117 Preble Street

Schlotterbeck Block (55 Unit Apt.)

**RE: B7 Design Review Comments
Level III Site Plan & Subdivision Application
Schlotterbeck Block – 117 Preble Street**

To: Elizabeth Boepple, Chair and Members of the Portland Planning Board
 From: Shukria Wiar, Planner
 Date: November 20, 2015
 Re: Schlotterbeck and Foss Building, 117 Preble Street, Schlotterbeck Block, LLC
 Project #: 2015-174 CBL: 033 E001 001 and 033 E005 001
 Meeting Date: November 24, 2015

Drawing file: Final Approved Plans / L7.0.Photometrics 10-23-15.pdf

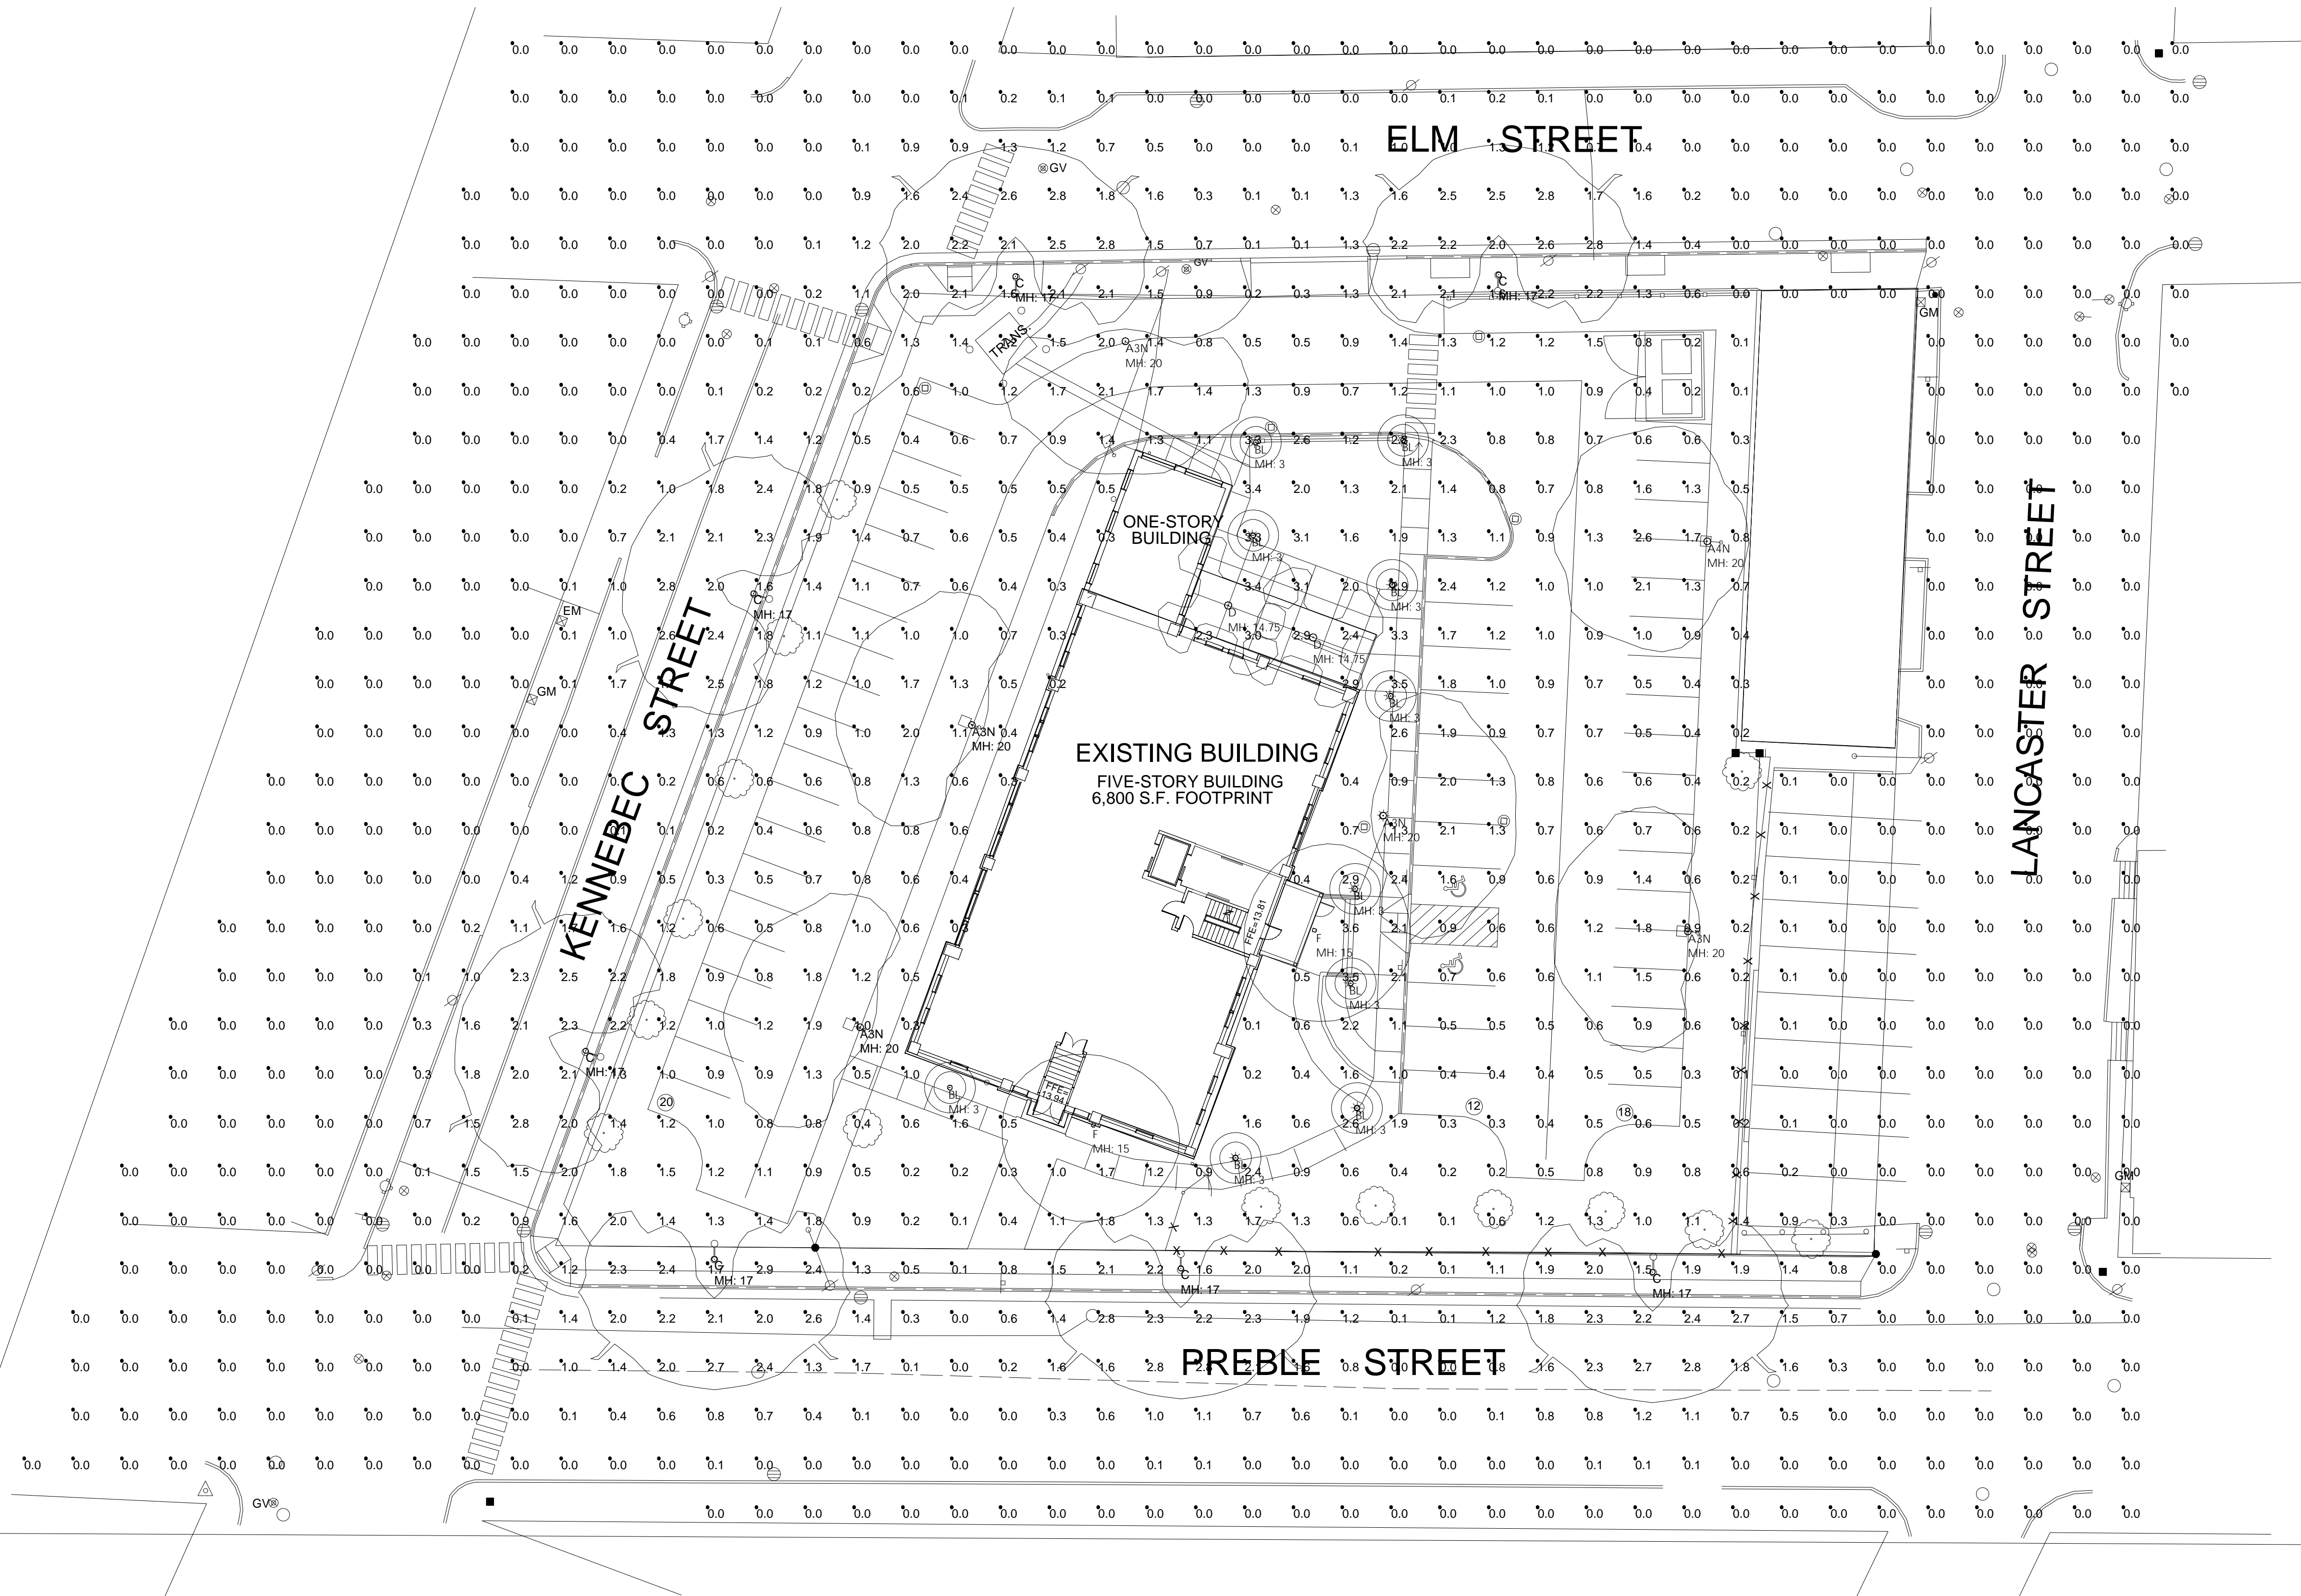
4. E-14: Illumination: We believe that, in this instance, B-7 Design Standard E-14 is in tension with Site Plan Standard zoning 14-526(c)6.b.(ii) which states that "[u]p-lighting ... is prohibited except for ... designated historic landmarks ..." For this building, downwash systems will not achieve the desired effect of highlighting the distinctive masonry designs between the fifth story floor and the

top of the parapet. We envision subtle uplighting akin to what is done at City Hall. We will work closely with staff on the color and intensity of the lighting to diminish light pollution impacts.

A lighting and photometric plan has been submitted. The proposal has noted bollard lighting at the walkways to the building (Plan 14 and 15) and up lighting on the building. The proposed bollard lighting fixture is not full cutoff and does not meet lighting standard. The applicant is proposing uplighting on the building; the proposed uplighting is not permitted. The B-7 zone references lighting under the Performance Standards Section 14-299 (n):

This building is a historic but is not designed as historic local landmark. The Planning Staff and the applicant will meet to resolve this issue.
